**From:** Anthony.Collier@hertfordshire.gov.uk  
**Sent:** 26 March 2018 14:37  
**To:** Planning  
**Subject:** Planning application 6/2018/0426/HOUSE - 42 The Ridgeway

**Response to Planning application from Hertfordshire County Council (T and CP GDP Order 2015)**

42 The Ridgeway  
Cuffley  
Potters Bar  
EN6 4BA

Formation of a crossover, carriage drive, car lift and associated works.

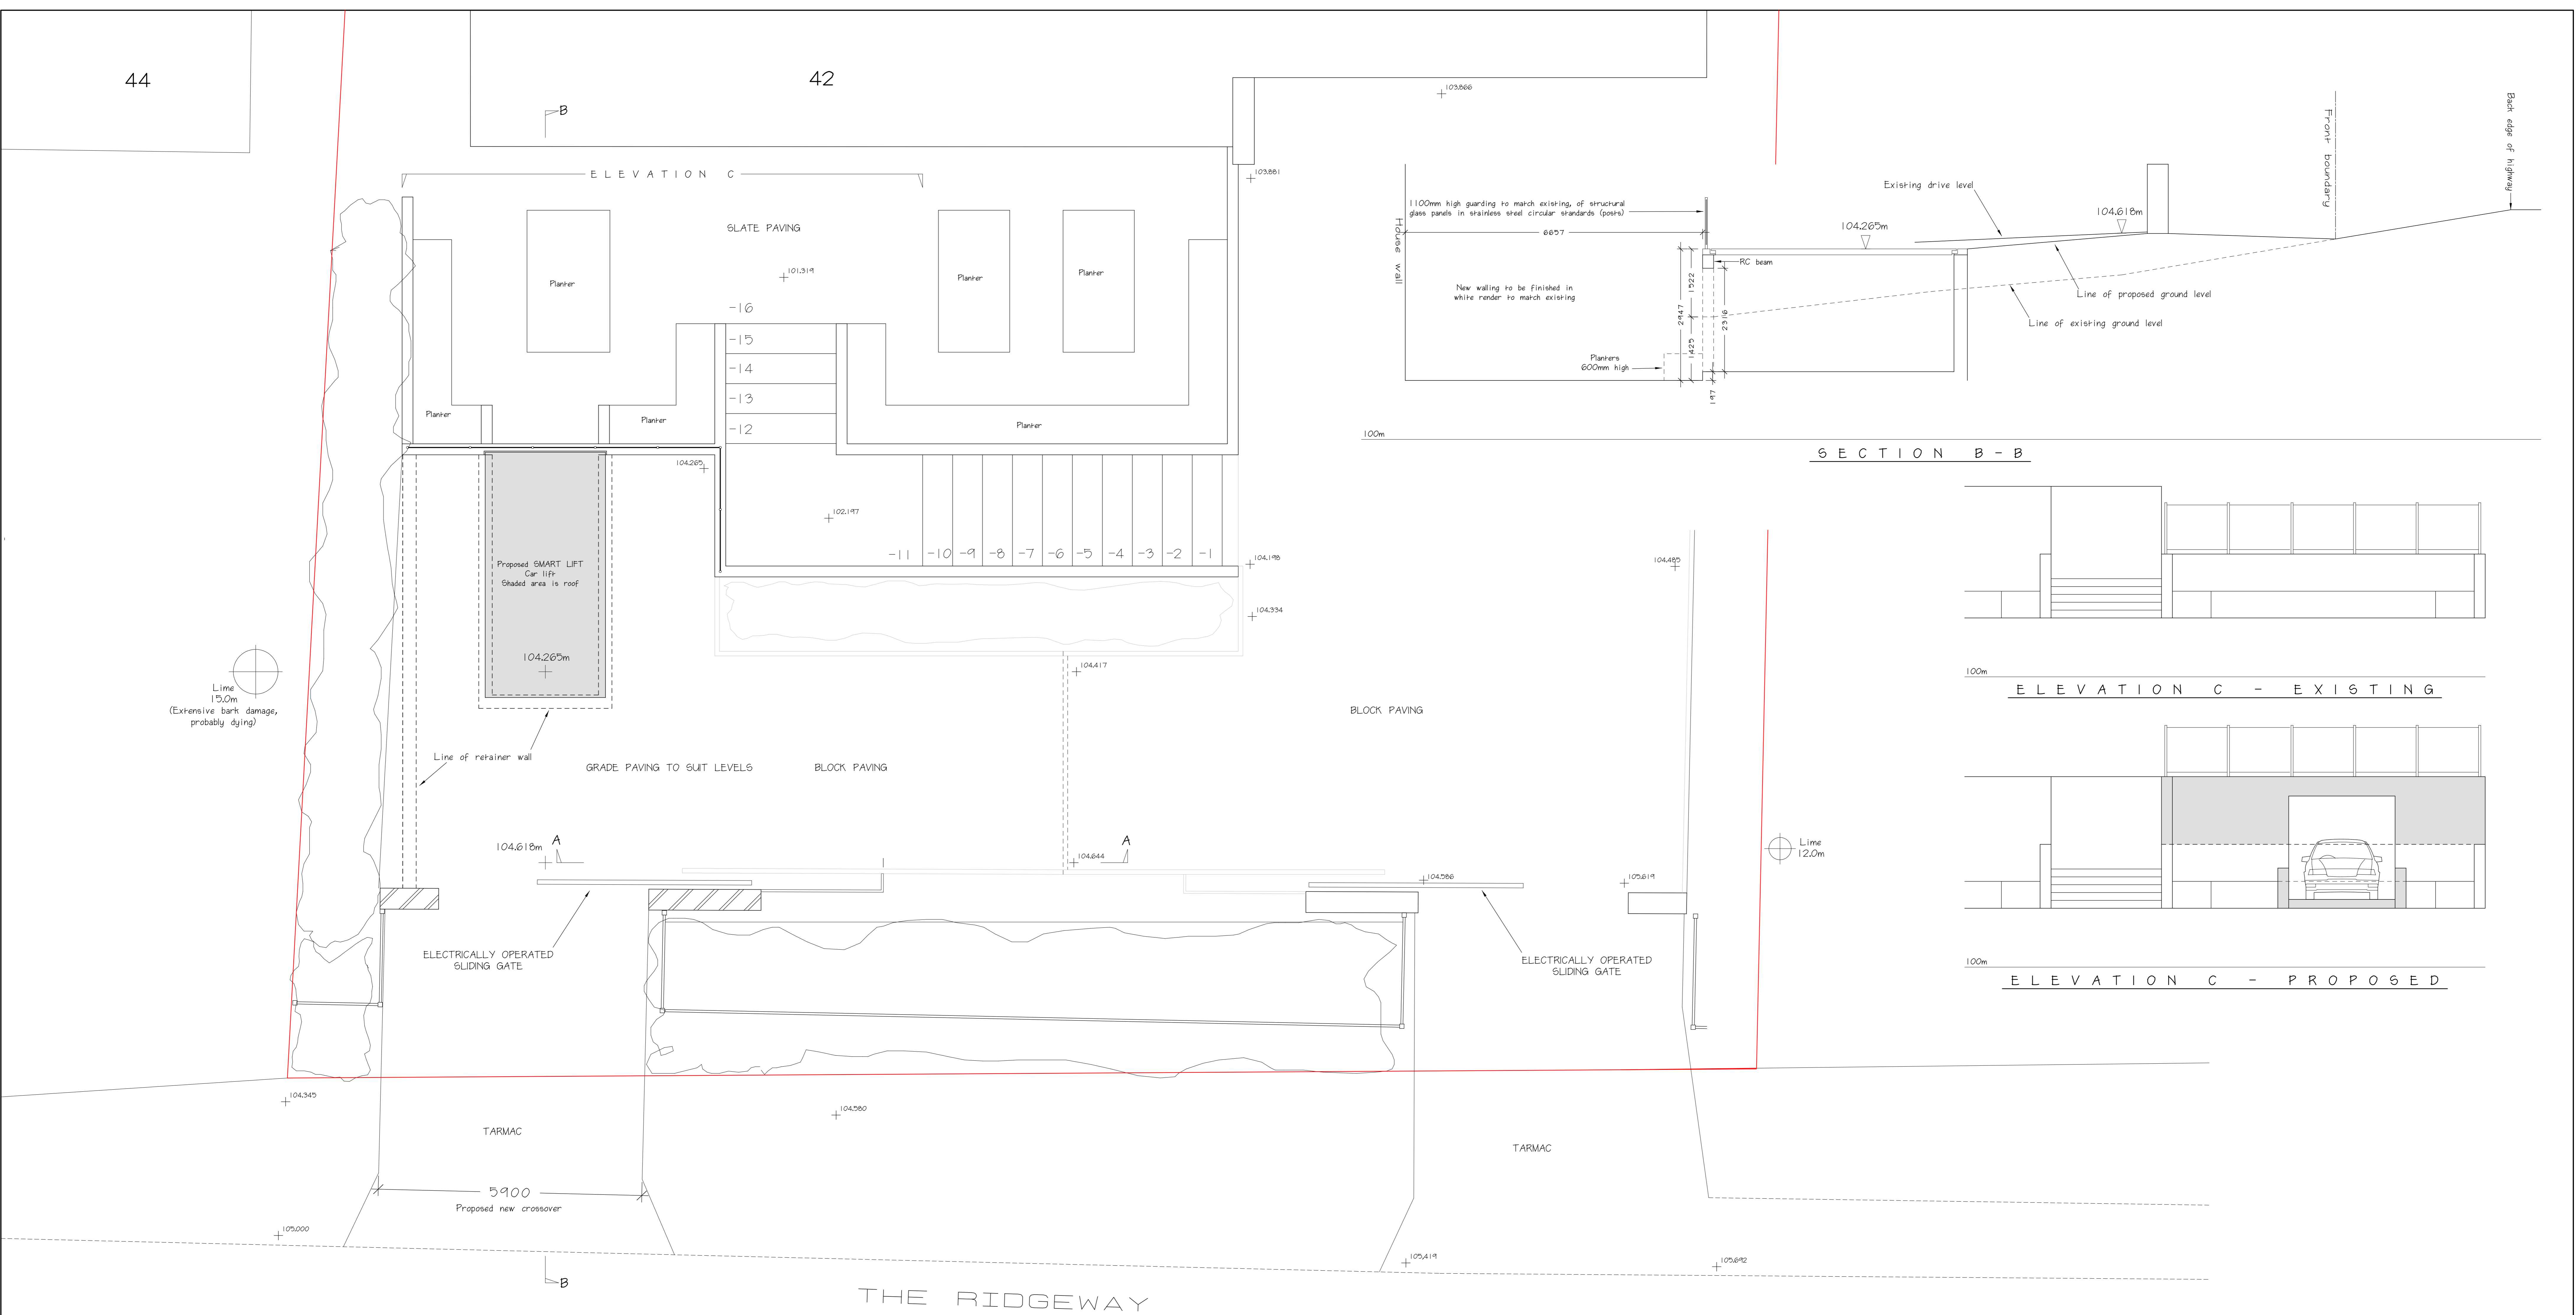
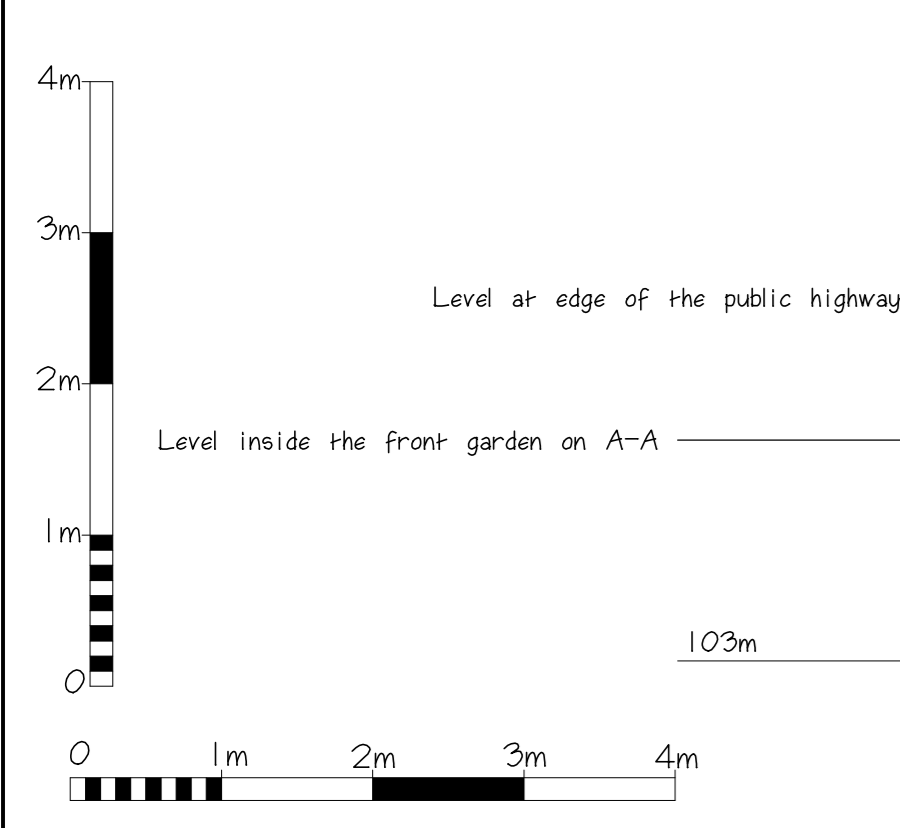
The proposal would create an additional vehicle access to the site, with dimensions in drawing showing there is suitable space for vehicles to draw clear of the highway and reduce the likelihood of causing any delay to other highway users.

the internal dimensions of the property allow vehicles to enter and exit the site in a forward gear and use the carriage function of having two cross overs

there is not a footway in front of the property so no pedestrian impact would occur.

it is considered unlikely that any impact to highway safety nor capacity would occur as a result of this proposal, and the highway authority present no objections
